Subject: 2026/90811 at location Trust Ford, St Andrew's Road, Huddersfield, HD1 6RJ

Please see ecological commentary below:

CLIENT:	TrustFord
PROJECT:	TrustFord Huddersfield Proposed Extension of Car Parking Area St Andrew Road Huddersfield HD1 6RJ
TITLE:	Proposed Site Plan (Part) 1 of 2 & Existing Site Plan (Part)
SCALE:	1:200@A1
STATUS:	REV: E
JOB NUMBER:	AA05-01
DATE:	March 2025
DRAWN BY:

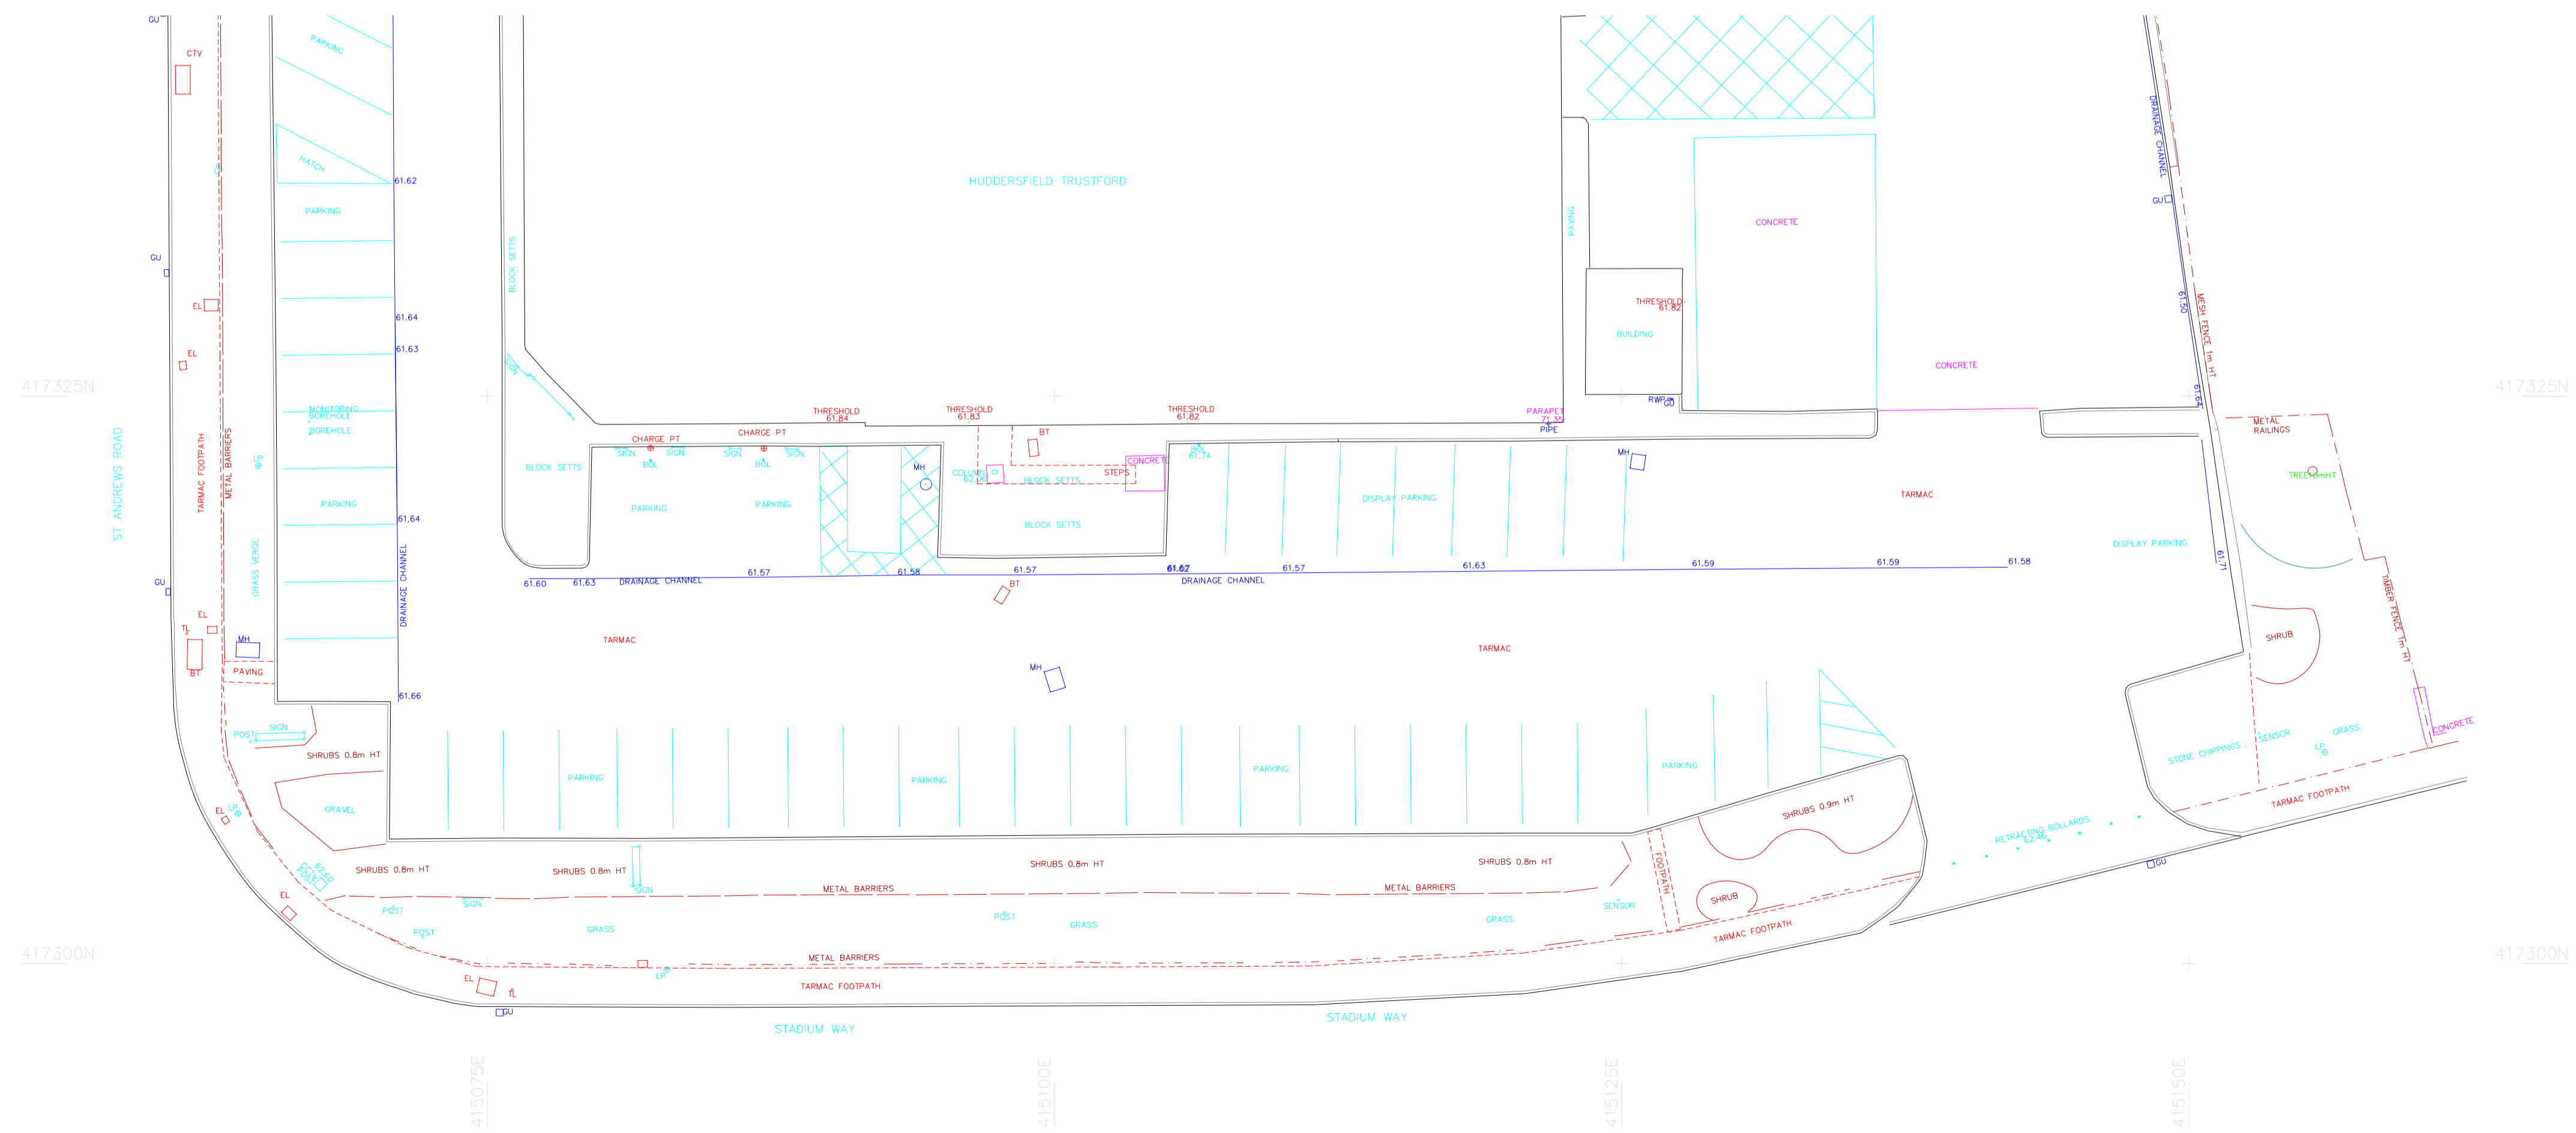
The tree onsite is to be retained. Tree protection measures will be added.

The grassland on the southern boundary is to be removed to make way for the extension of hardstanding. It is a small area and nest to a road. The building appears to be in a good state of repair. As a result, a PEA is not warranted.

A Hedgerow and Tree Protection Plan detailing measures for the protection of trees and hedgerows during the works will be submitted to and approved by the LPA prior to the commencement of works on site, including site clearance and delivery of materials.

Hedgerow and tree protection measures will include temporary fencing for the protection of hedgerows in accordance with BS 5837:2012 Trees in relation to design, demolition and construction – Recommendations. Any alternative fencing type or position not in accordance with BS 5837:2012 will be agreed in writing by the LPA prior to the start of development.

Appendix 4: Post Development Habitat Plan

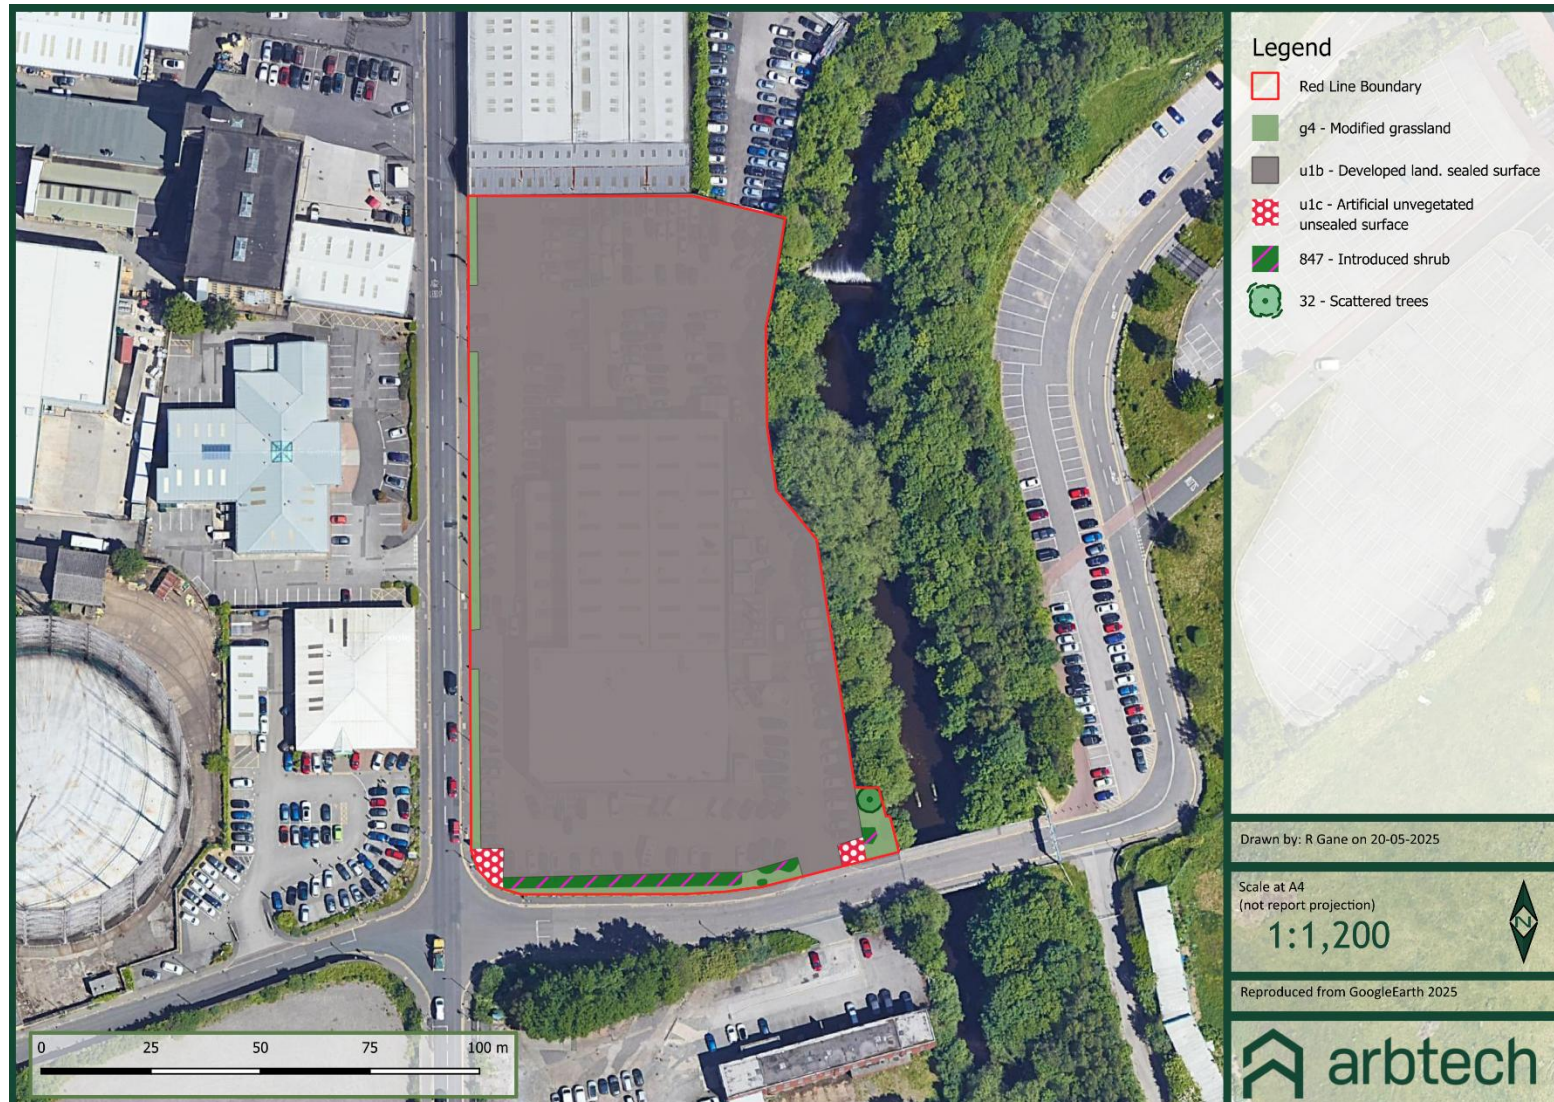
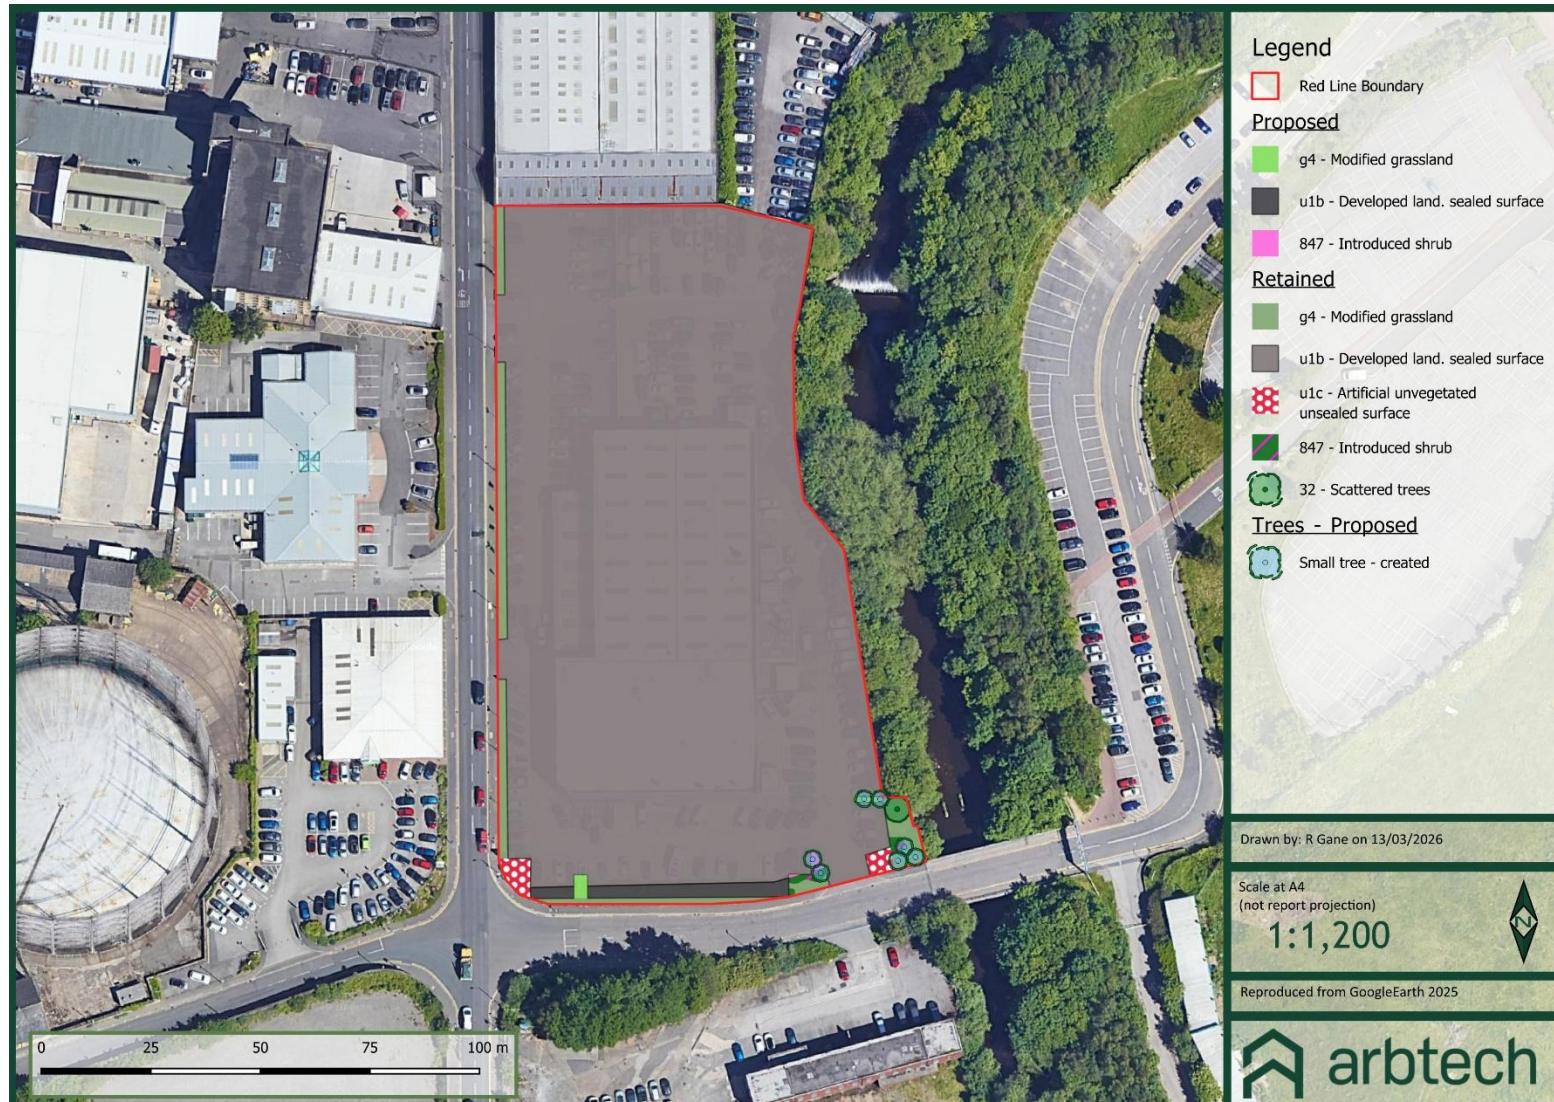
There will be an onsite net gain of 0.05 (19.06%) habitat units. This will be through the creation of low to medium distinctiveness habitats.

We consider that the onsite element of the BNG proposal will not result in significant onsite gain as it would be delivered by. This does therefore not need to be secured for 30 years but could be secured by a simple landscaping condition, if appropriate, to ensure it is provided and maintained for an aftercare period.
